SOUTH HOLLAND DISTRICT COUNCIL

To: Planning Committee - 23 September 2026

Purpose: To consider Planning Application H16-0692-25

Description: Development of Site to provide a Food Store and Drive-Thru, along with all Associated Works and Access

Proposed Site Layout

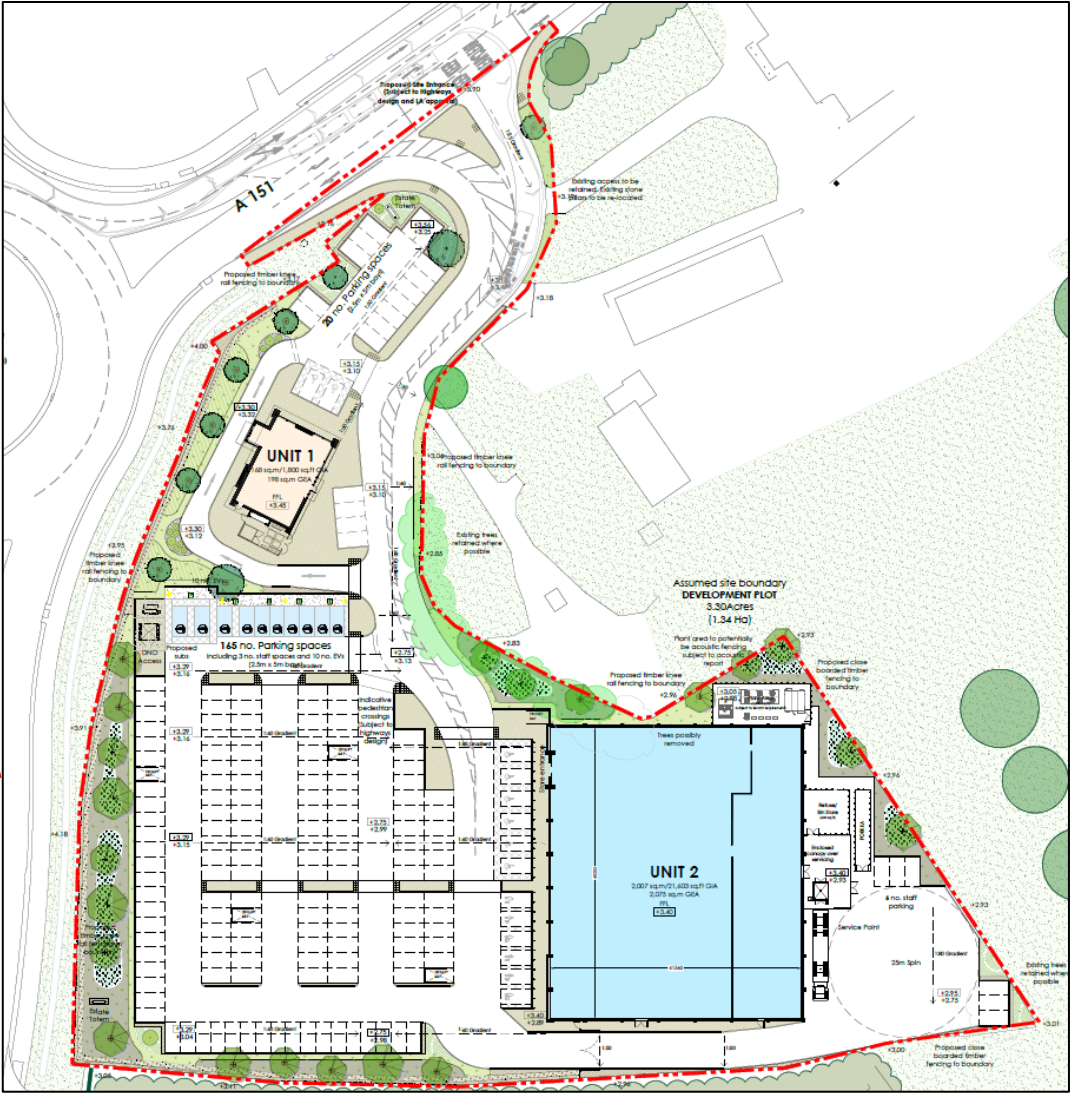
- 6.19 **Anglian Water - Comments**
- 6.20 **Original Response**
- 6.21 We need to inform you that there is an Anglian Water owned Water Mains pipe which is crossing the development site and is affected by the proposed development. We have reviewed the submitted 19627 THPW 00 XX DR A 1000 Rev D Proposed Site Masterplan plan and 19627 SFH XX XX DR L 1001 Rev P01 Landscape Masterplan. The proposed Unit 2 and proposed Landscape are affected by the above Anglian Water owned water mains pipe located on site. Anglian Water does not permit this asset to be located within the curtilage of the proposed building, and we do not permit permeable paving or suds features over our assets. The water main pipe should be located in areas of public open space and/or adoptable highways to ensure on-going maintenance and access is possible. It is also not clear that the applicant has taken the presence of our water mains pipe into consideration when preparing the site layout and landscape masterplan.

- 6.22 We also must advise that Anglian Water does not permit any new trees to be planted within 4.5 metres of the established alignment of any of our assets. Any trees within 4.5 to 6.0-metres of our assets, should be planted in tree pits with the appropriate root barrier protection. Once fully matured the canopy of any tree should not extend across and potential damage our asset and obstruct Anglian Water future access to the pipe. To overcome our objection, the applicant is required to revise the above layout plans and take in consideration the easement required. These plans need to take account of the location of the asset and should be referred to in any master planning exercises or site layout plans submitted as part of this planning application.

- 6.25 Anglian Water has assets close to or crossing this site or there are assets subject to an adoption agreement. Therefore, the site layout should take this into account and accommodate those assets within either prospectively adoptable highways or public open space. If this is not practicable then the assets will need to be diverted at the developers cost under Section 185 of the Water Industry Act 1991. or, in the case of apparatus under an adoption agreement, liaise with the owners of the apparatus. It should be noted that a diversion works should normally be completed before development can commence.
